DOC18/216601
SSD8707

Exhibition of Concept Redevelopment Application for Ivanhoe Estate, Macquarie Park - SSD 8707

Attachment 1 – Office of Environment and Heritage (OEH) comments - Ivanhoe Estate Concept Redevelopment SSD 8707

Table 4-1 Design Peak Flood Levels (m AHD) at Ivanhoe Estate

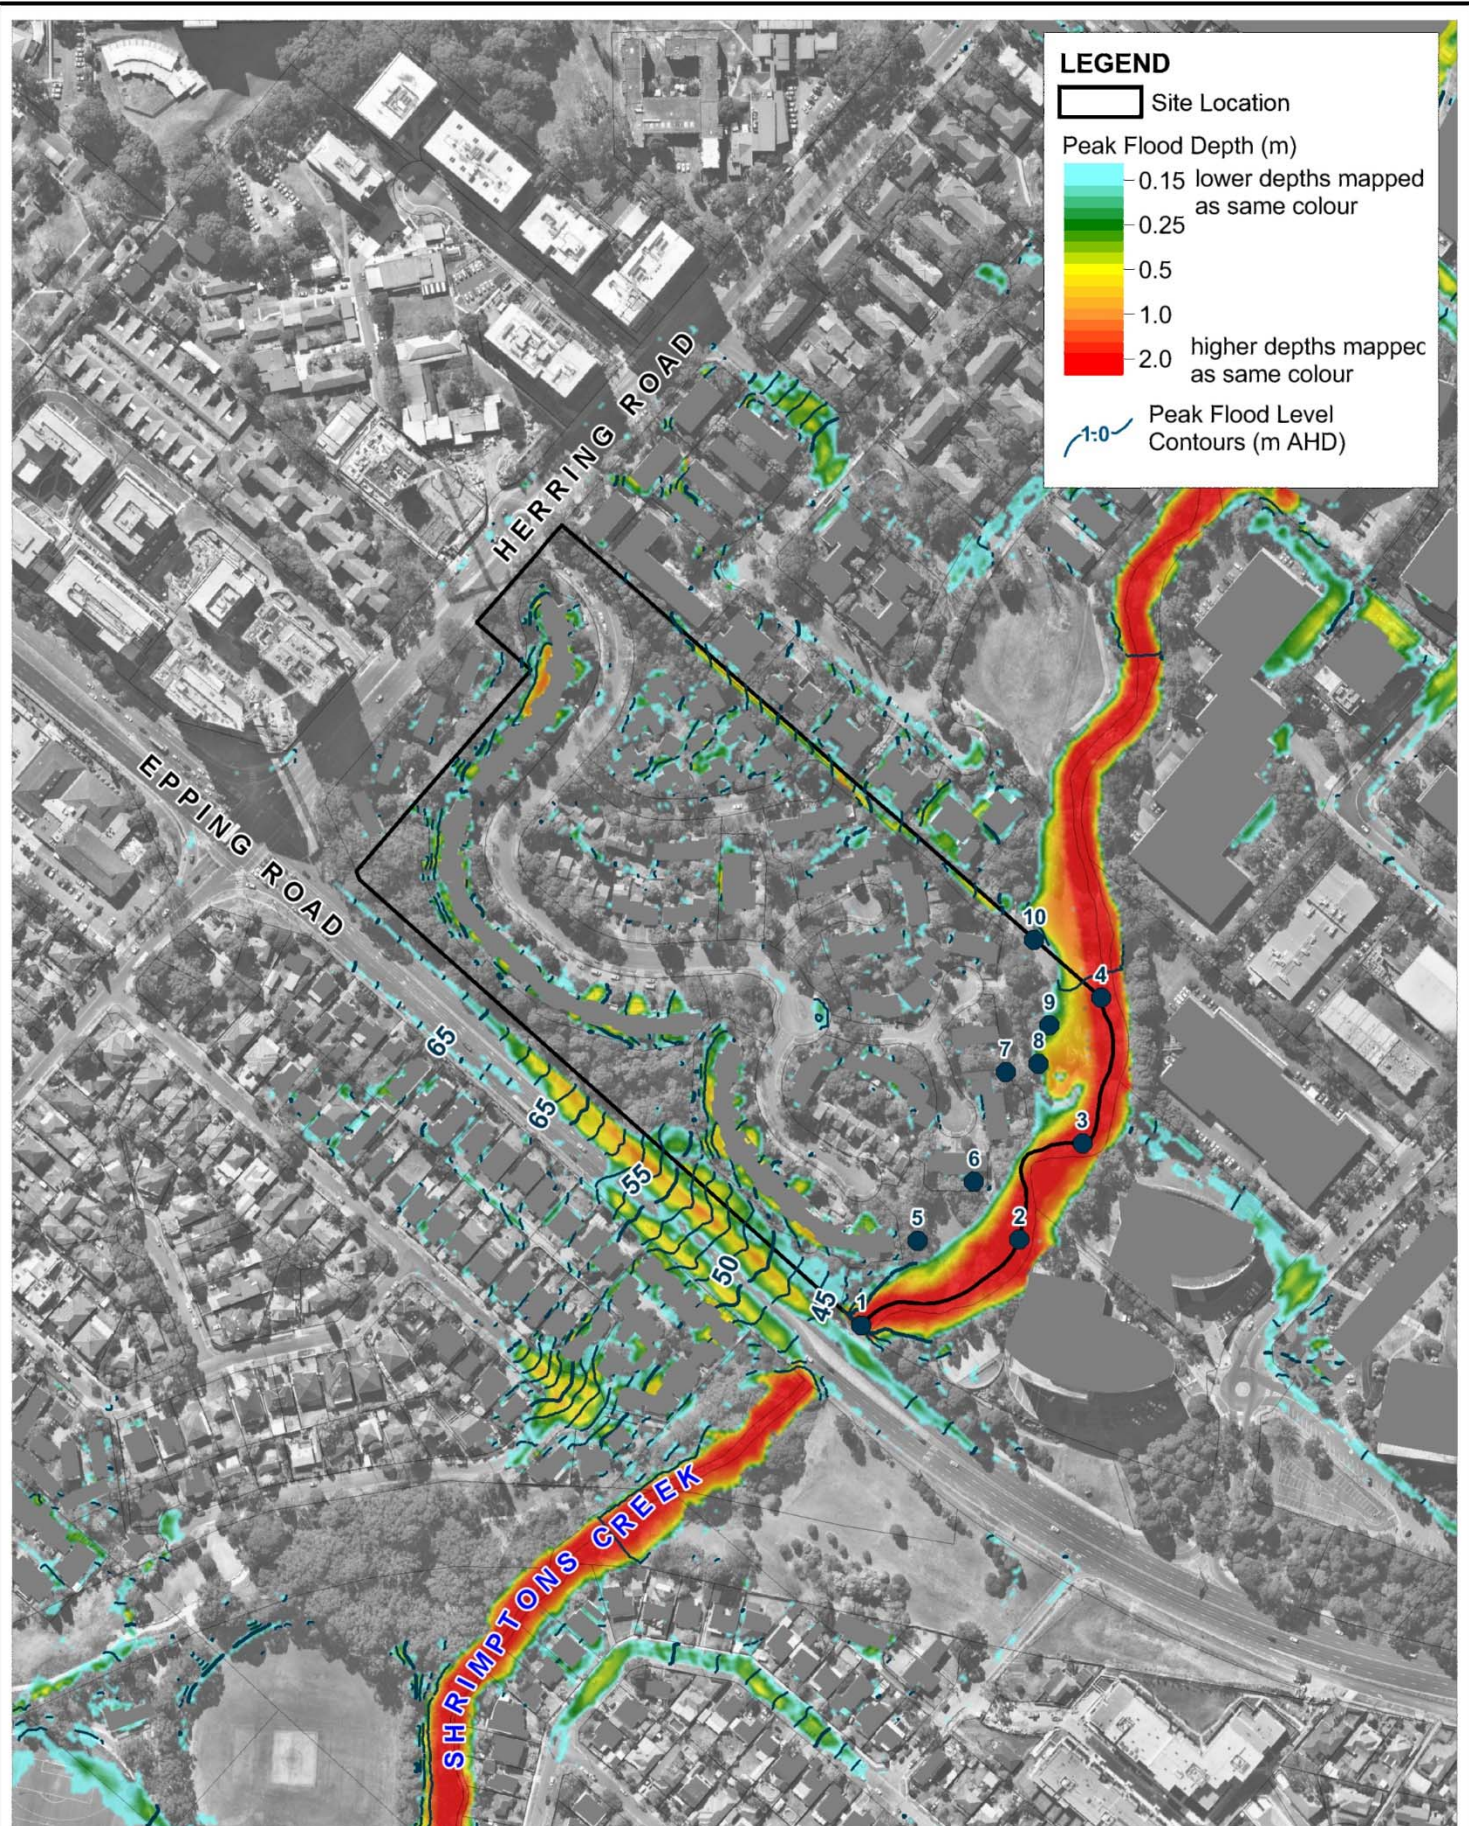
- In Table 5-1, the flood level results look to be out of order. It looks like an error has been made as the 20y levels are 1, 2, 3 etc and in the proposed development scenario 20y, 100y and PMF levels do not make sense. 20y levels are more than 2m higher than the 100y and PMF levels. It looks like the columns have been moved across by one. Please clarify this matter.
- In Table 5-1 and 5-2, assuming that the error in the columns is clarified for Table 5-1, the locations that have NFI (No flooding indicated) are not consistent between the tables. For example, in the current PMF scenario at location 5 a flood level is indicated in Table 5-1 but in Table 5-2 it has NFI. Please clarify this matter.
